**KIRKLEES METROPOLITAN COUNCIL
INVESTMENT & REGENERATION SERVICE**

DELEGATED DECISION TO DETERMINE PLANNING APPLICATIONS

Reference No:	2024/62/91097/W
Site Address:	47, Park Road, Crosland Moor, Huddersfield, HD4 5DB
Description:	Demolition of existing garage, erection of single storey front and rear extensions and extension to form first floor
Recommending Officer:	Tom Hunt

DECISION - REFUSED

Proposed First Floor Plan Scale 1:100
(Ref: HD45DB47v4)

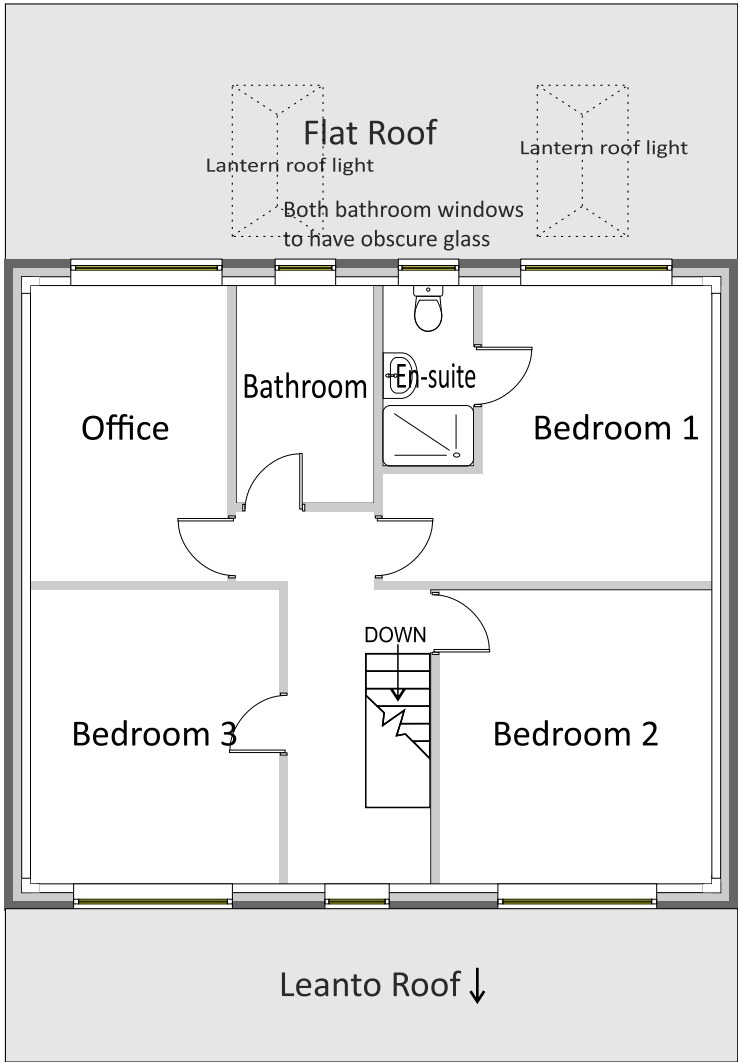
The neighbour has its side elevation facing no. 47 and has one, narrow, first floor side window set modestly close to the rear and is separated by its driveway and a shared low stone wall. The proposed first floor windows would have some potential for overlooking to this window given the proximity of the two elevations separated by 9.9m at first storey; the two bathroom windows will be obscurely glazed however the bedroom windows would be clear glazed. It is not known from its glazed appearance, Council records or historic sales records whether no. 11's window serves a habitable room. Officers consider that bedroom one's window has the most potential for loss of privacy due to being the closest one to no. 11's side elevation window however this could be acceptable as they would only have oblique views. Bedroom two is at a sufficient distance so as to only have very oblique views of this window. It is noted that the additional windows would have some additional overlooking of no. 11's rear garden however in a finely balanced judgement, this would not introduce a substantially different relationship in terms of overlooking or loss of privacy to its existing neighbours. Due to no. 47's position approximately 9.9m (measured from the proposed two-storey host) to the northeast of no. 11, there would be no significant impact on overshadowing or overbearing.

Proposed Front Elevation
Scale 1:100 (Ref: HD45DB47v4)

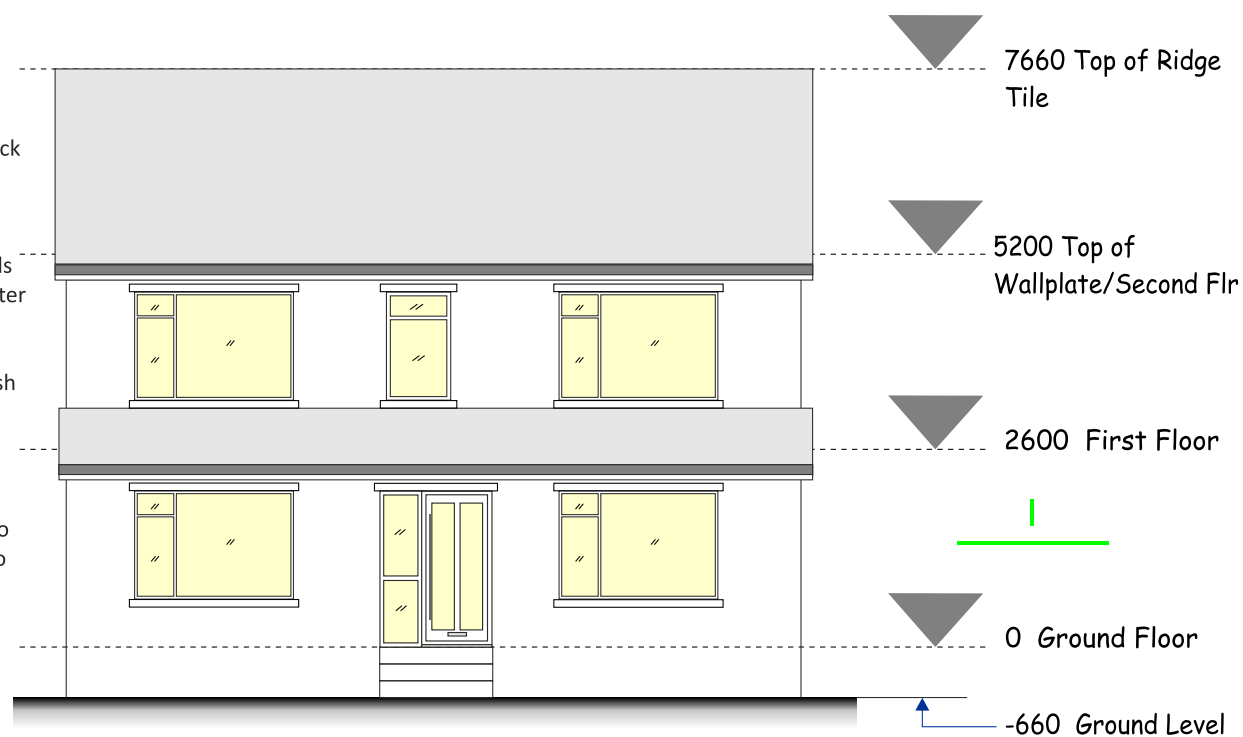
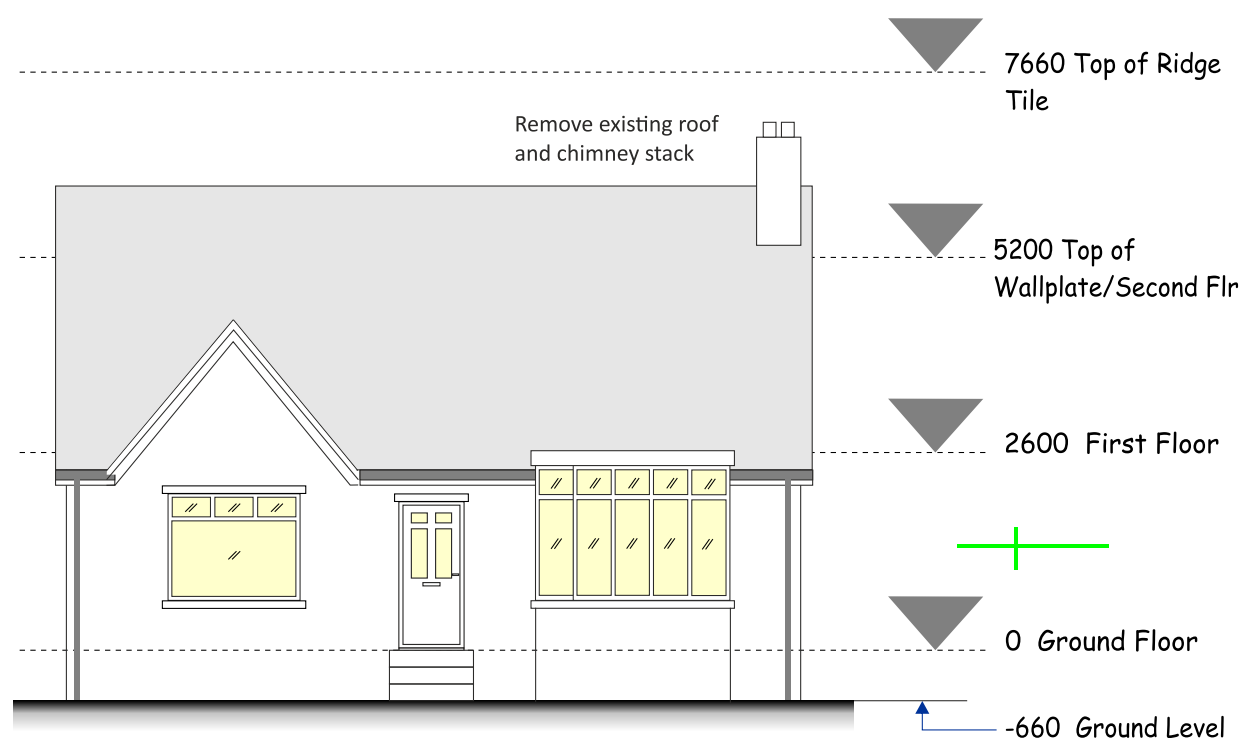
The SPD notes that *"front extensions are highly prominent in the street scene and can erode the character of the area if they are not carefully designed. Large extensions (single and two-storey) and conservatories on the front of an existing house are likely to appear particularly intrusive and will not normally be acceptable."*

Paragraph 5.14 of the SPD (page 27) states that they are usually unacceptable due to the impact on the character of the area and will not be permitted unless the house is well set back from the pavement or is well screened, the extension would be small and subservient to the property, be well designed and have materials matching the existing features of the original house in order to respect the original character of the host and area. The proposal would have a single-storey front extension which is limited to the original building width. This would be set back 6.5m from the footway/highway at the front and bring the property closer at a minimum of 4.3m to the side footway on a prominent corner plot and it would be set behind the building line of no. 45. Whilst it would not unduly encroach on the highway as demonstrated by being set back behind or approximately within its existing neighbouring building lines. It would appear to add a very prominent quantum of bulk and massing as demonstrated by its full width spanning the front elevation of the host and would not be considered as a small front extension to a newly two storey host. Seen as part of a pair of bungalows with no. 55, this would create a visually unbalanced pair with the additional front extension and the first floor extension and would erode the present sense of spaciousness and openness within the streetscene.

Considering the streetscene, the locality either have their front elevations with bay window extensions protruding ~1m from the primary elevation or without. In the corner plot, the proposal would extend 2m and would add more bulk

and massing than the existing arrangement to the streetscene ensuring that it would appear as a dominant and uncharacteristic addition to the streetscene and its plot.

Considering the proposed fenestration, in the locality, houses typically have large bay windows to ground floor and a narrow pair of vertical windows with mullions or vertical pairs at ground aligned with the first floor. The proposed fenestration would appear to have a domestic style, while this would not be in keeping with the locality, Officers consider this to be relatively acceptable being limited visual impact to a detached building.

Proposed Side Elevation Scale 1:100 (Ref: HD45DB47v4)

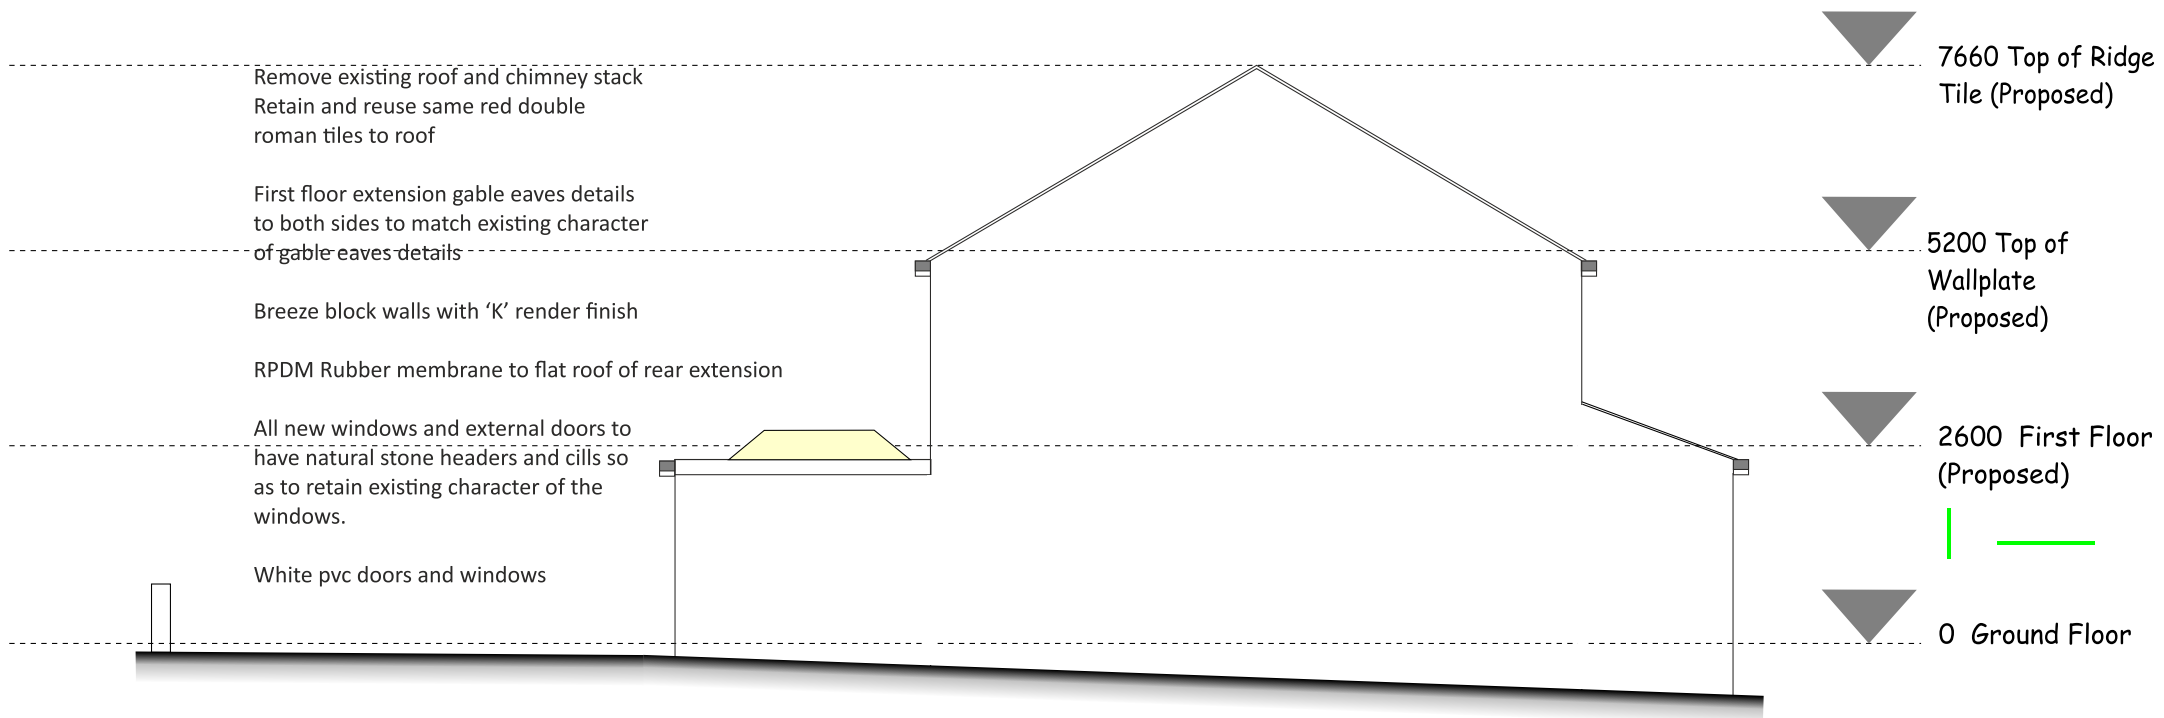
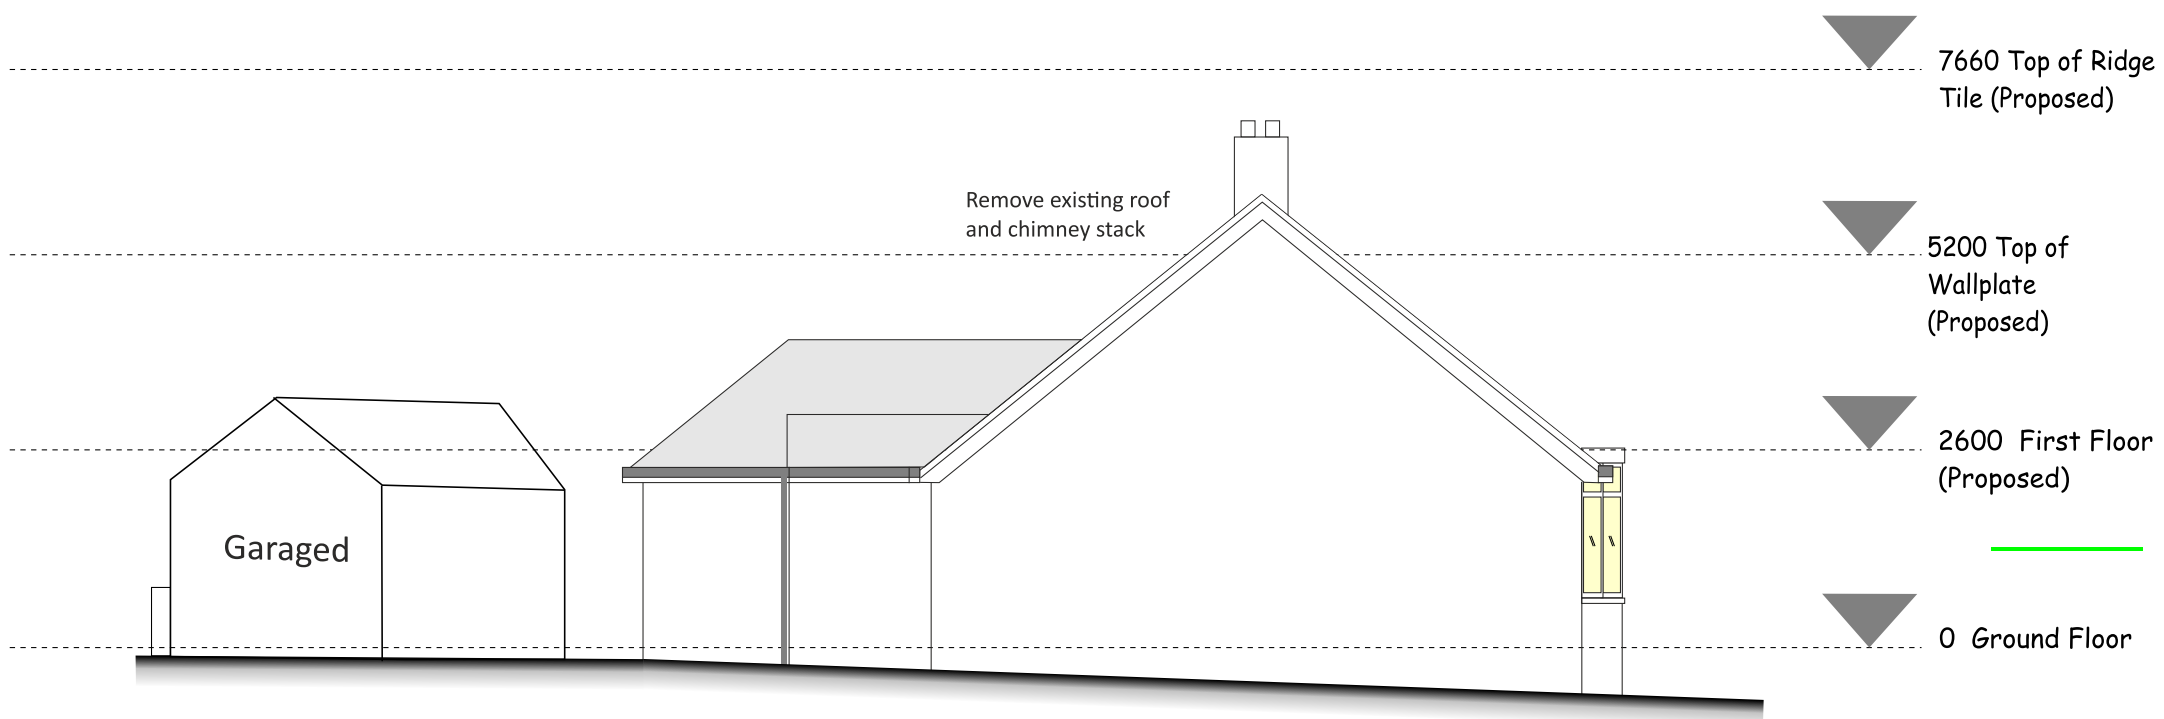
character of the area through changing the heights, rhythm or form of a roof in relation to the rest of the street scene." In the absence of a street scene plan it is difficult to assess how the development would relate to neighbouring properties. It is noted that the neighbouring dwellings are two storey and as such some increase in height could be supported should it be demonstrated that the increase in proportions of the building sits comfortably within the street scene (as required at 5.32 of the SPD). The scale and form of development submitted would detract from the character of the existing street particularly when taking into account the architectural merit of the dwellings to the south east. The proposed dwelling would not appear to relate well to existing development within the street.

The limited plot provides some significant constraints to the possible scale of the proposed built development without appearing as overdevelopment and this was noted within the previous similar application on the site. As previously discussed, the cumulative impact of the extensions would appear to create a visually unbalanced two-storey property to its neighbouring northwest bungalow at no. 55. In addition, it would create a dominant two-storey host within a very constrained plot with additional extensions to the front and rear eroding the original character and design of the property contrary to Key Design Principles 1 and 2 of the House Extensions and Alterations SPD. Whilst it is noted that the use of render finish to the elevations and red tile to the roof would echo the property's original character, this would not outweigh Officer concerns that the proposal would appear as a dominant and discordant addition in its limited plot and to the streetscene and fail to respect the original character and design of the host.
